**Appendix D to the Relevant Representations of Natural England**

**Ornithology Compensation Case**

The construction and operation of the Five Estuaries Offshore Wind Farm located approximately 57km from the Essex Coast in the Southern North Sea.

Planning Inspectorate Reference EN010115

DRAWING NUMBER: **3**

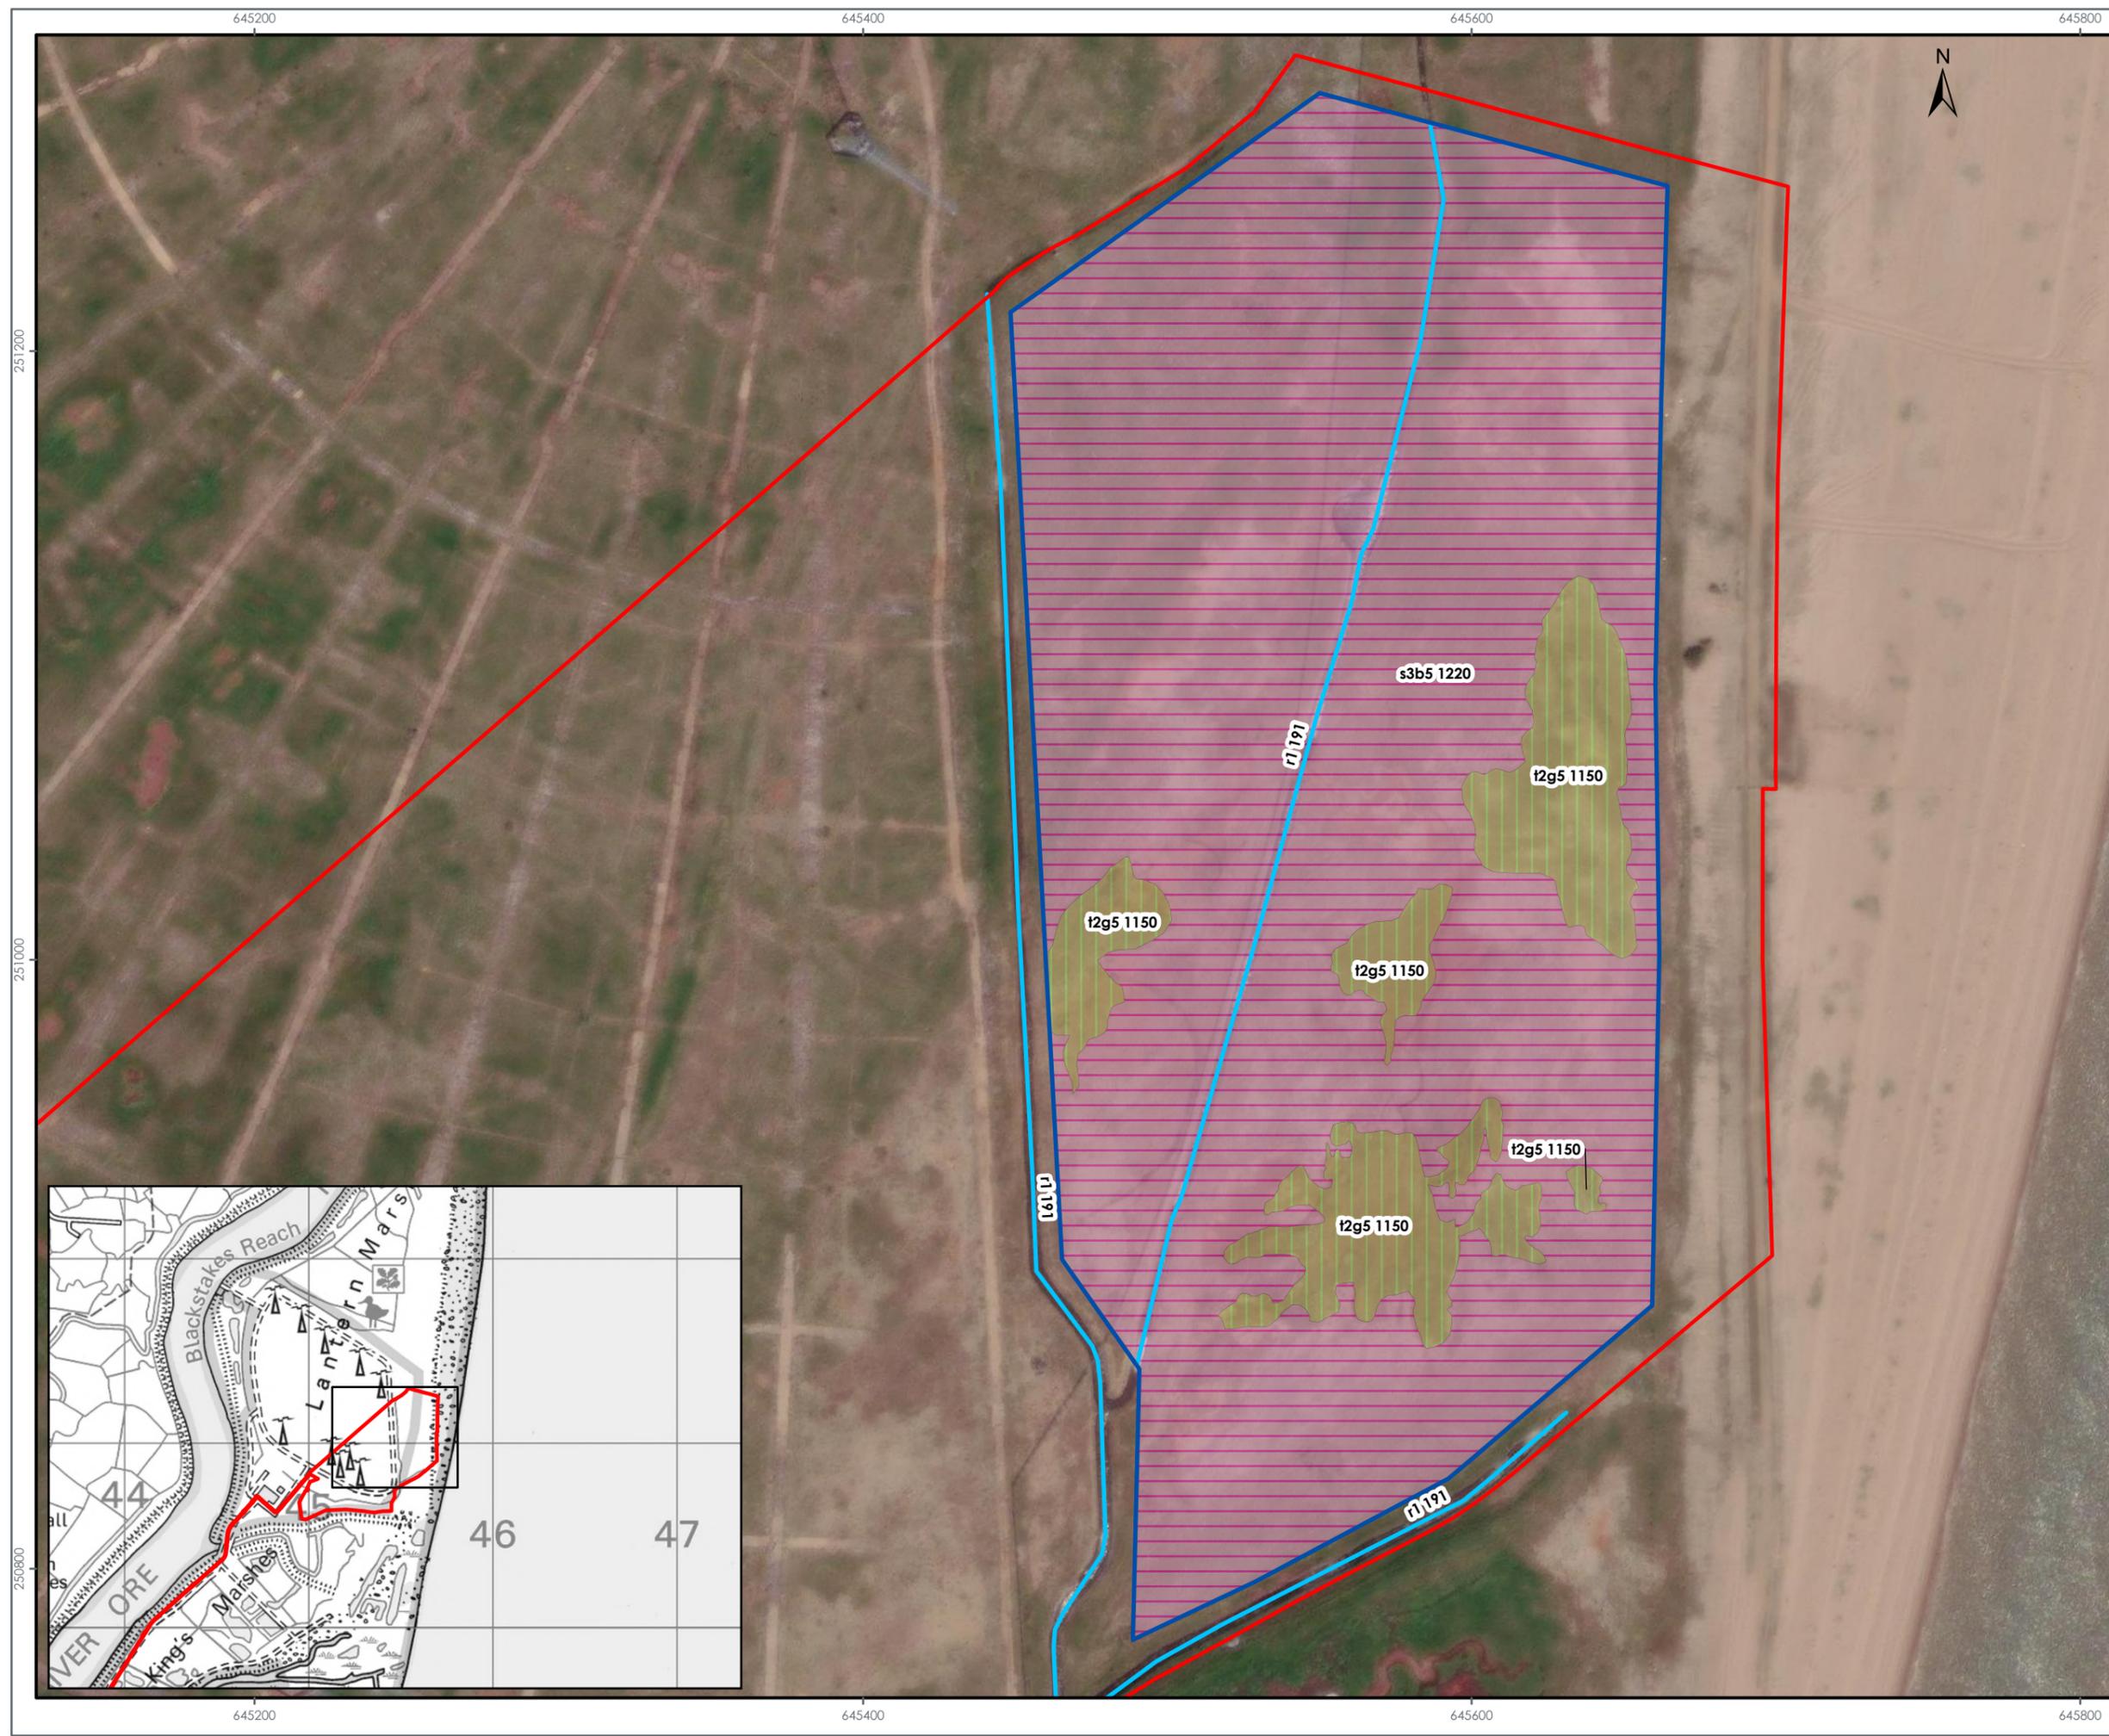
Location of measure	D29		As negotiations with landowners at both sites remain on-going, there is currently uncertainty whether or not either site can be secured for the lifetime of the project. Within the AOE SPA, the onshore ecology may also affect the location of the proposed predator-proof fencing – see Appendix J – Onshore Ecology.
Long term implementation	D30		We advise that this approach to compensation is broadly adequate. However, for the predator-proof fencing proposal in the AOE SPA, no schedule for fence maintenance and checks has been provided or details about how this will be done and by whom. Fence maintenance will be crucial to prevent predator incursions and a key component of on-going management throughout the year. Plans will also need to be in place to address fence breaches so these can be resolved quickly. For the proposal at Outer Trial Bank, workable plans for monitoring and biosecurity will need to be in place.

Uncertainty	D33		<ul style="list-style-type: none"> <li>• Permission to use the site within the AOE SPA and erect the predator proof fencing has not yet been secured. Landowner agreement remains under negotiation.</li> <li>• The gulls may choose not to occupy the fenced site or do so at some point only after the wind farm becomes operational, thereby incurring a compensation deficit.</li> <li>• Fence maintenance has not been described and it is unclear who and how this will be done for the duration of the project.</li> <li>• Impacts on designated features of the SAC, SSSI and Ramsar site need to be better understood and mitigated.</li> <li>• Use of the OTB site remains under negotiation with the landowner and so has not been agreed yet.</li> <li>• It is possible that rat predation proves not an issue on OTB and therefore removing rats from the site makes no difference to the gull population size or breeding success.</li> <li>• The following information will become available during examination and may influence the final choice of sites or management approach: a) the success of the SPR/Vattenfall scheme in the 2024 breeding season (expected Q4 2024); b) further data on the colony size and health at Outer Trial Bank (expected Q3 2024) and c) Information from TCE and Defra on how the Outer Trial Bank site could be secured and delivered (expected Q2 2024).</li> <li>• The current primary limitation of population growth could be food supply and consequently the nesting habitat improvements proposed here could yield no measurable change in the number of breeding gulls at either site.</li> </ul>
